# **Lime Down Solar Park**

**Planning Inspectorate Reference:  
EN010168**

**Wiltshire Council Comments on Submissions  
Received at Deadlines 2a and 3**

**Deadline 4 (10 July 2026)**

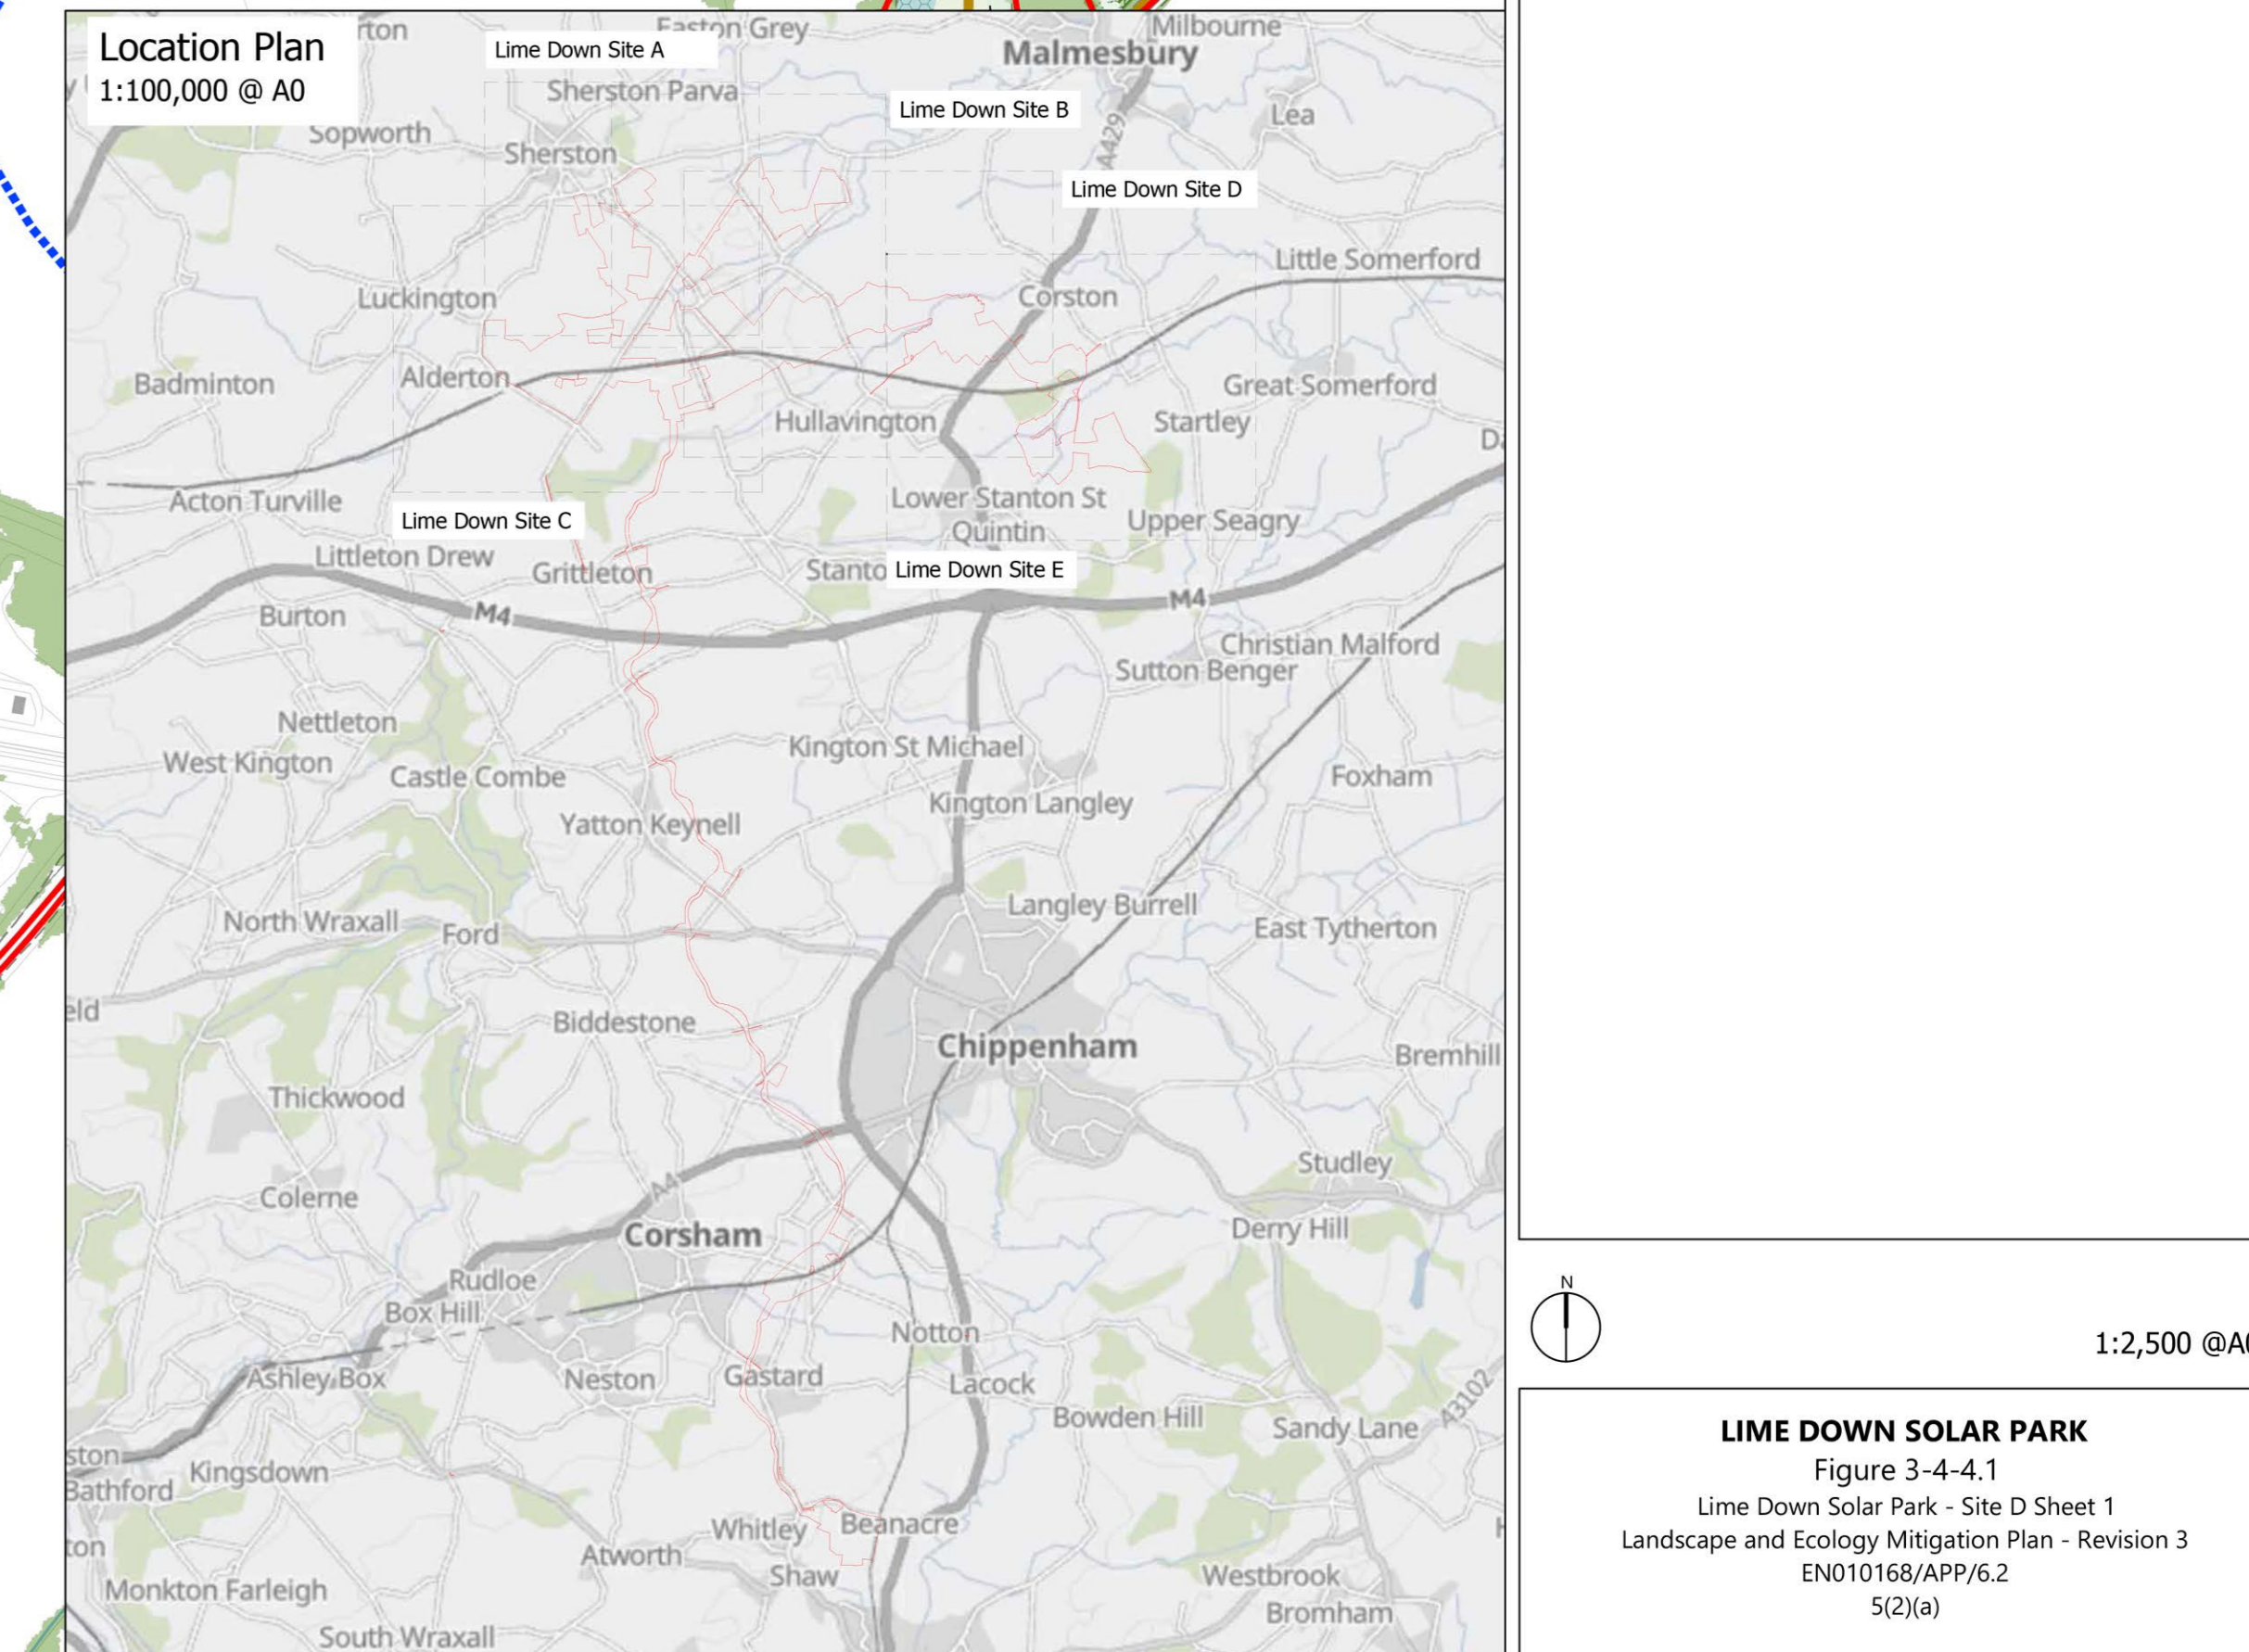
**5. 6.2 ES Volume 2, Figure 3-4-4.1 and 3-4-4.2 Landscape and Ecology Mitigation Plan (Rev 3) [[REP3-037](#)]**

- 5.1. Given the potential for substantial land take requirements, the council considers that indicative footprint areas for potential soil storage stockpiles should be added to the plan to demonstrate that these would not impact upon embedded mitigation buffers and stand offs, and to reduce the risk that these would end up being located within areas of ecological mitigation or enhancement.
- 5.2. It would also have been helpful if the amendments could be tracked or clearly annotated on the plan, so that it is easier to decipher what the changes to the plan comprise.
